August 28, 2015

Subject: Second Tee Business Park – Unit #9
Applicants: Moongate Properties, LLC
Response Letter #1

On behalf of Moongate Properties, LLC, we are responding to your e-mail transmission dated August 11, 2015 that contained staff review comments related to the Level II Amended Site Plan application. The responses and supplemental information are provided to assist while you continue your ongoing review:

PROJECT	SECOND TEE CONDOMINIUM ASSOCIATION BUSINESS PARK EXPANSION
SHEET TITLE	UNIT 9 GRADING, DRAINAGE AND EROSION CONTROL PLAN
CLIENT	1039 RIVERSIDE LLC

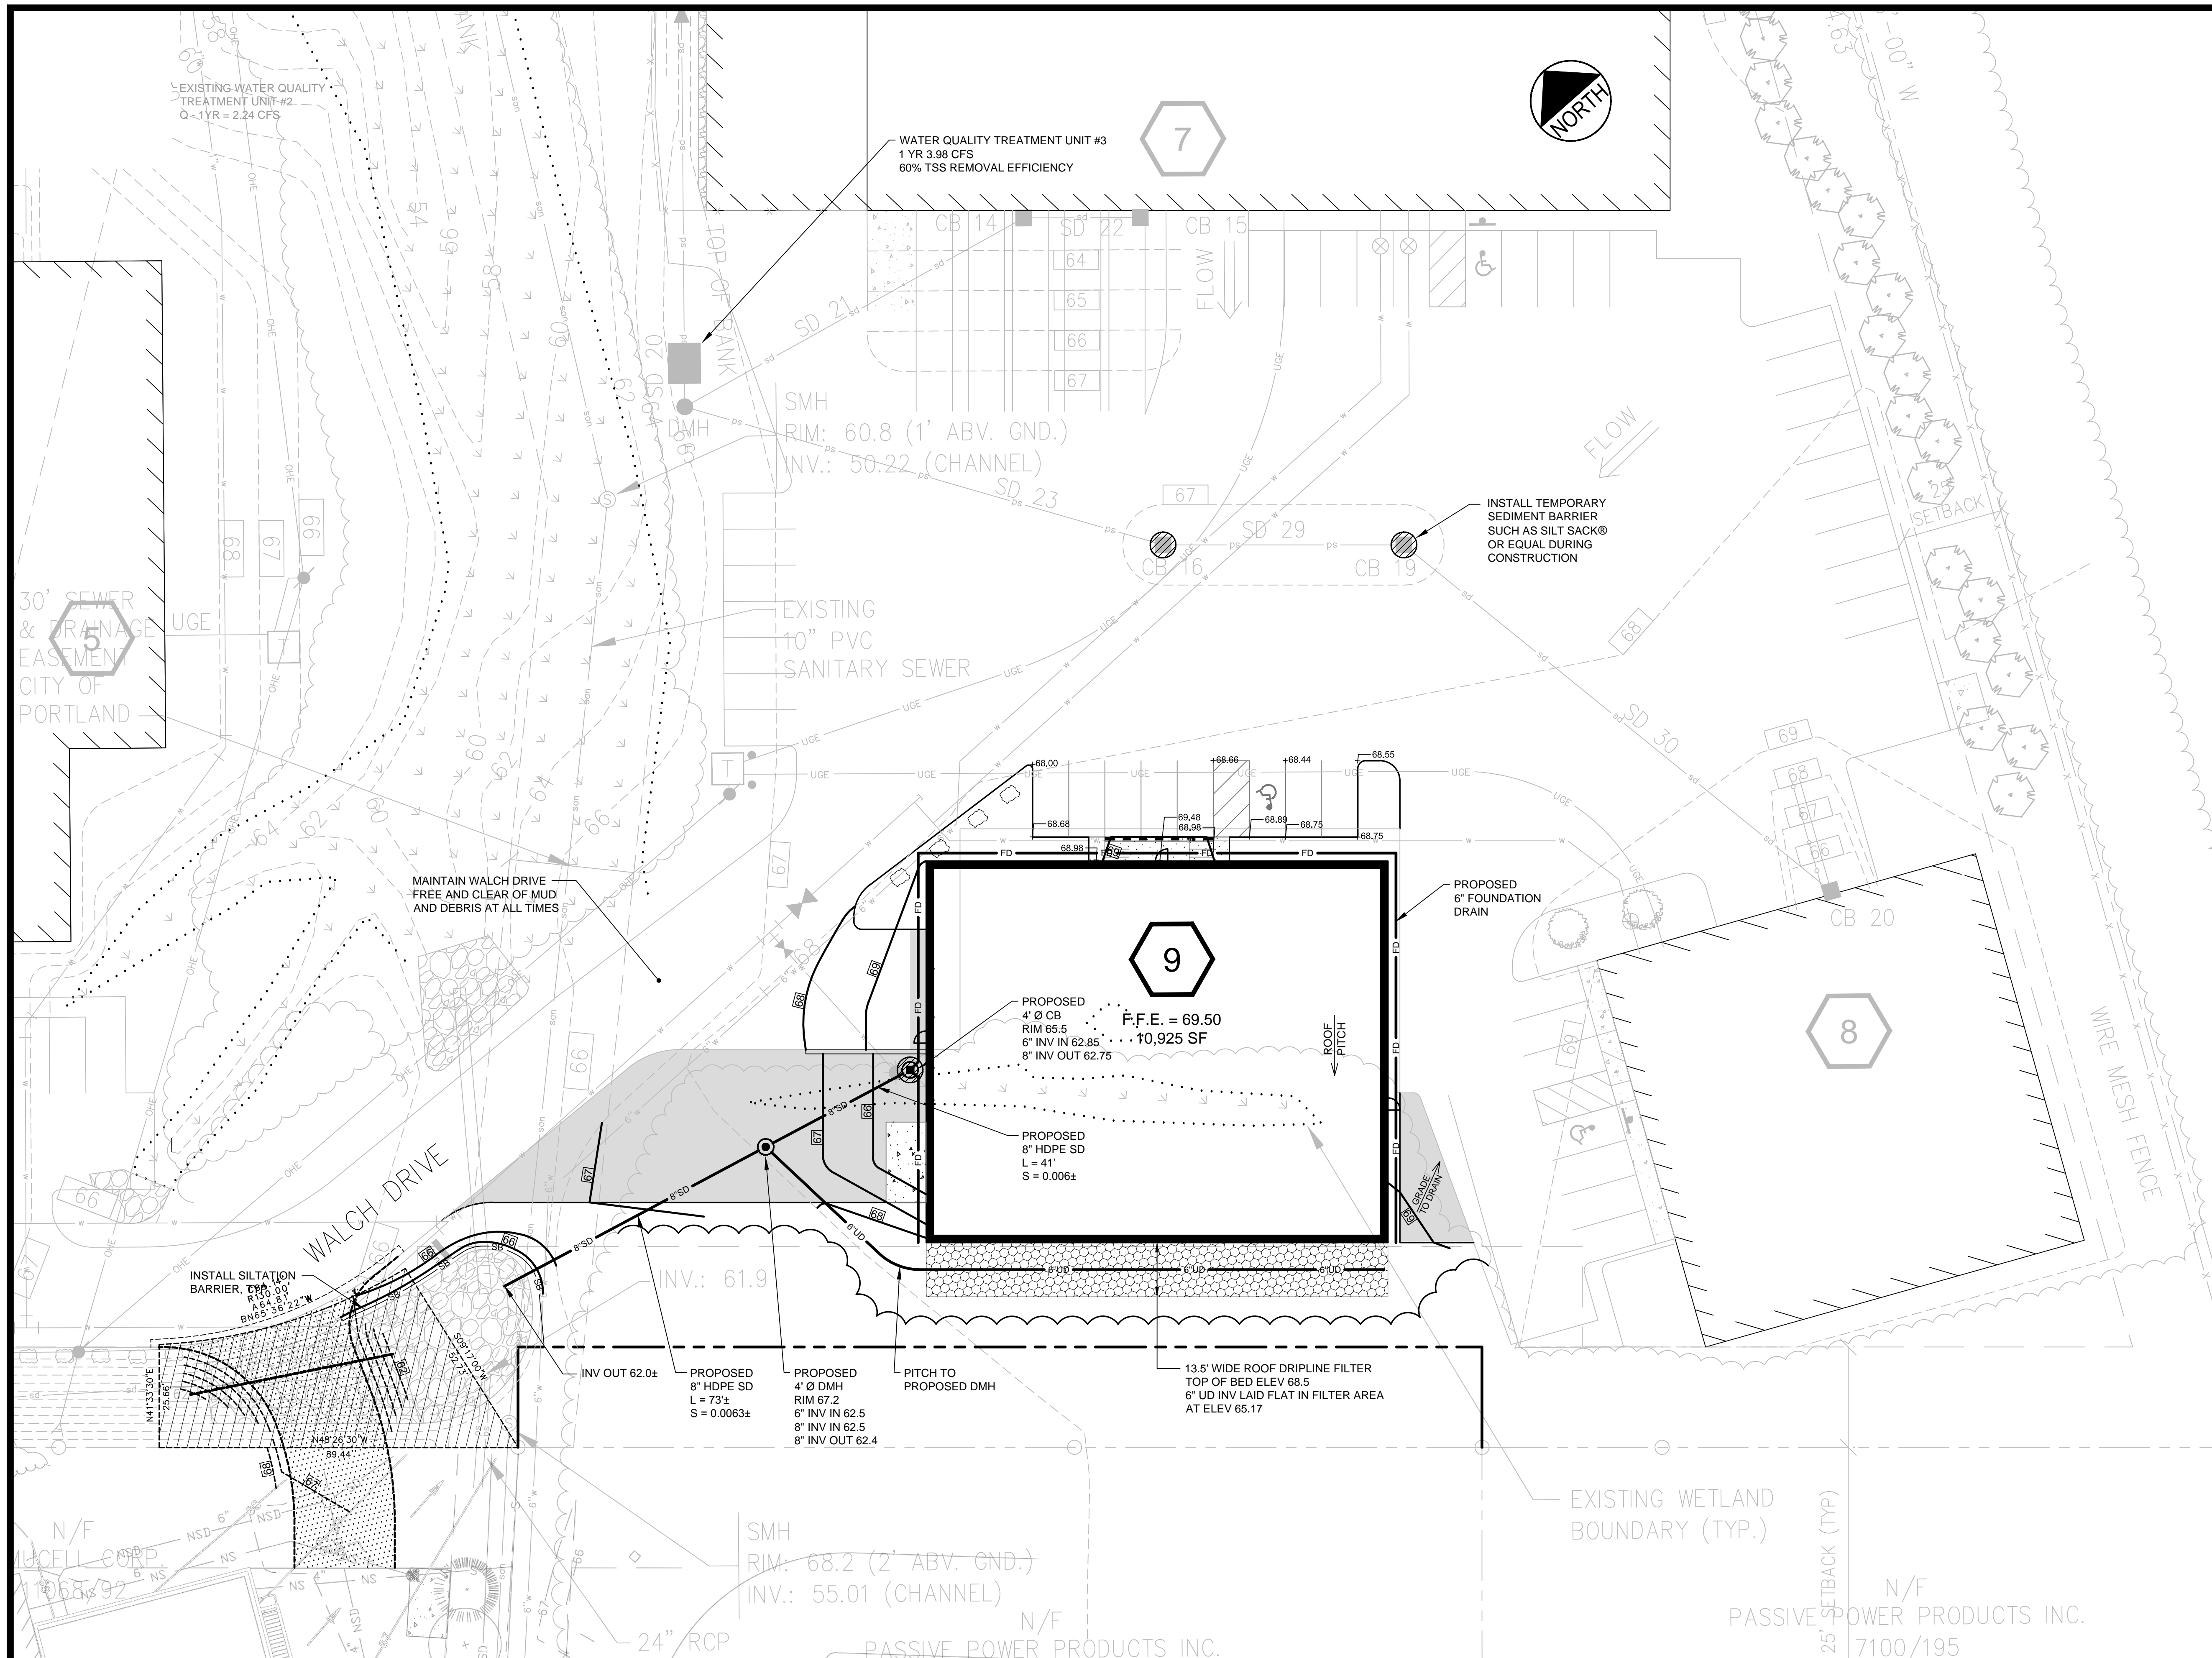
Stormwater – *I understand that this site was subject to a Site Location of Development Permit (by the City) in 2004 and that this application requires an amendment to that. Have you spoken to the MDEP? I also understand that the MDEP requires developments after the new standards came in (2005) to meet the new standards. Therefore please submit a summary of what was permitted and what has been developed for the business park as a whole so that we can understand what area of Unit 9 (including new paved areas) needs to be addressed in terms of stormwater flows and quality.*

As there is a small amount of increased impervious area we have offered, as a water quality treatment measure, a roof line drip strip filter at the rear of the proposed Unit #9. This BMP has been sized in accordance with Chapter 7.6 of the MeDEP BMP. In addition, there will be a new 4' diameter catch basin installed to capture runoff from the loading dock area where most of the runoff from the new impervious pavement area will be directed. The catch basin will be fitted with a 3' sump and hooded outlet to provide removal of sediment and floatables from any runoff.

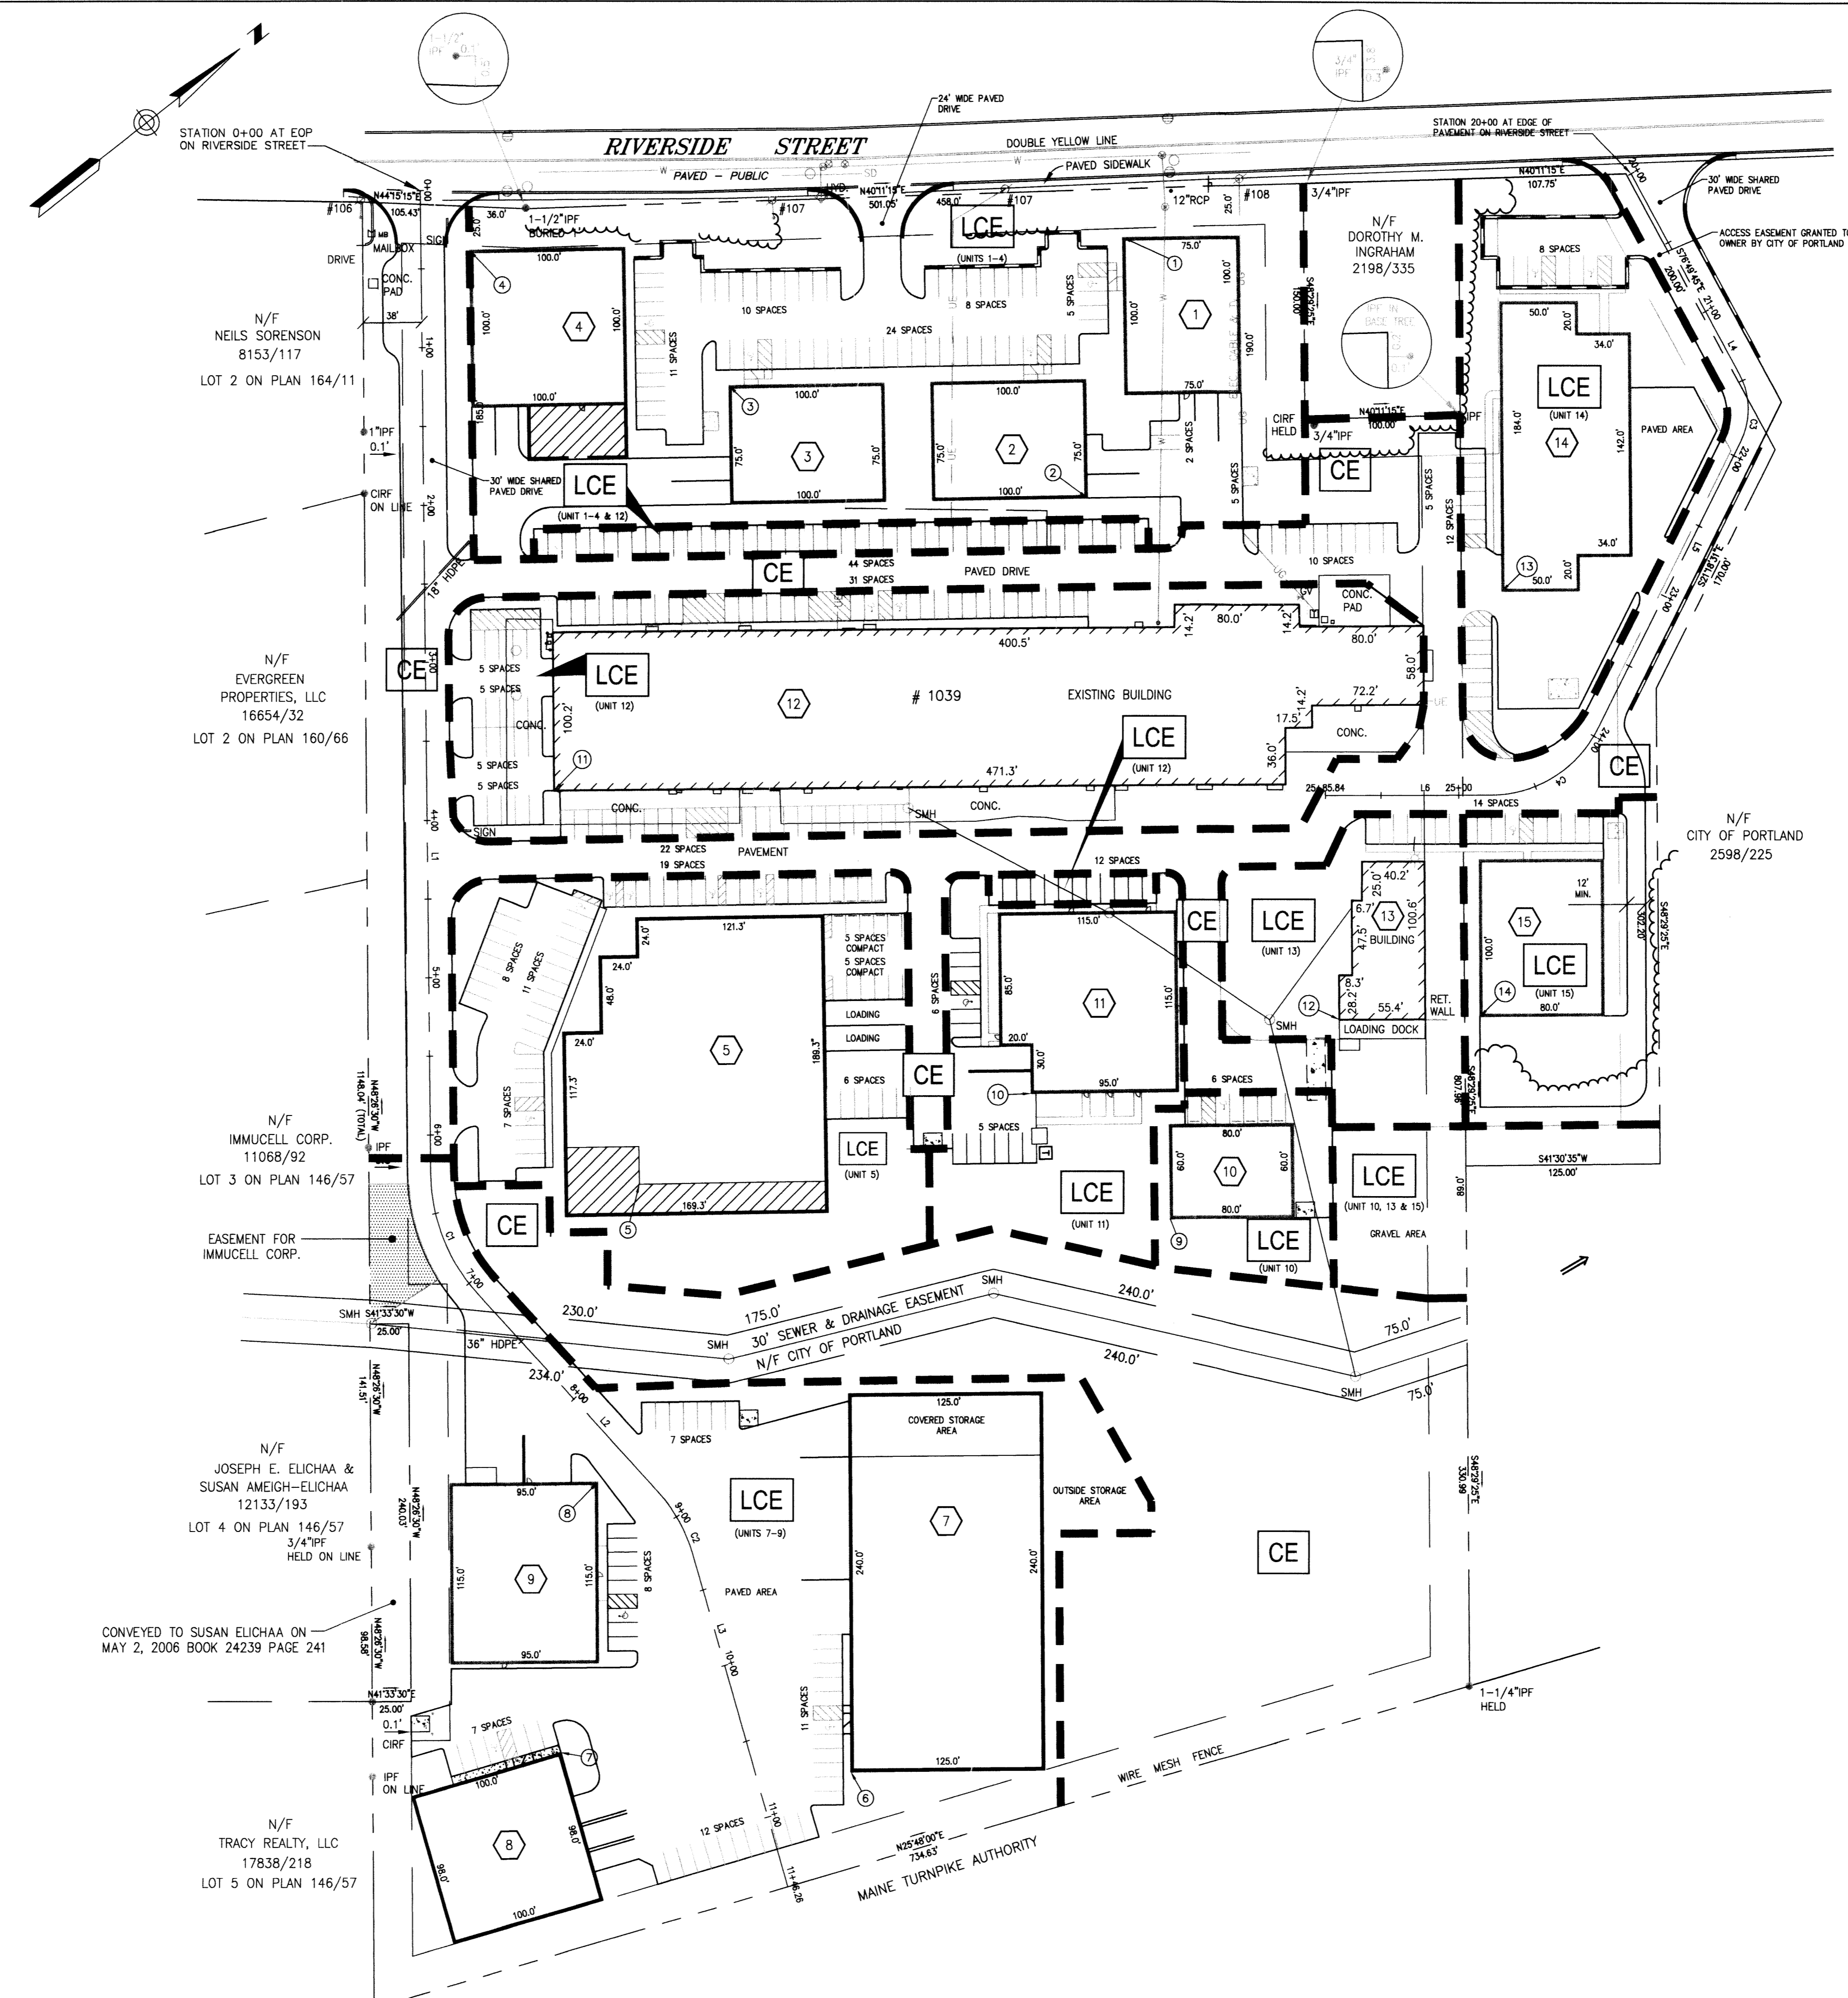
Plat Amendment – Please ensure the Plat amendment matches the site plans in terms of location and dimensions of the Unit #9.

The attached 4th Amended Recording Plat has been prepared to coincide with the latest layouts for Units 9 and 11.
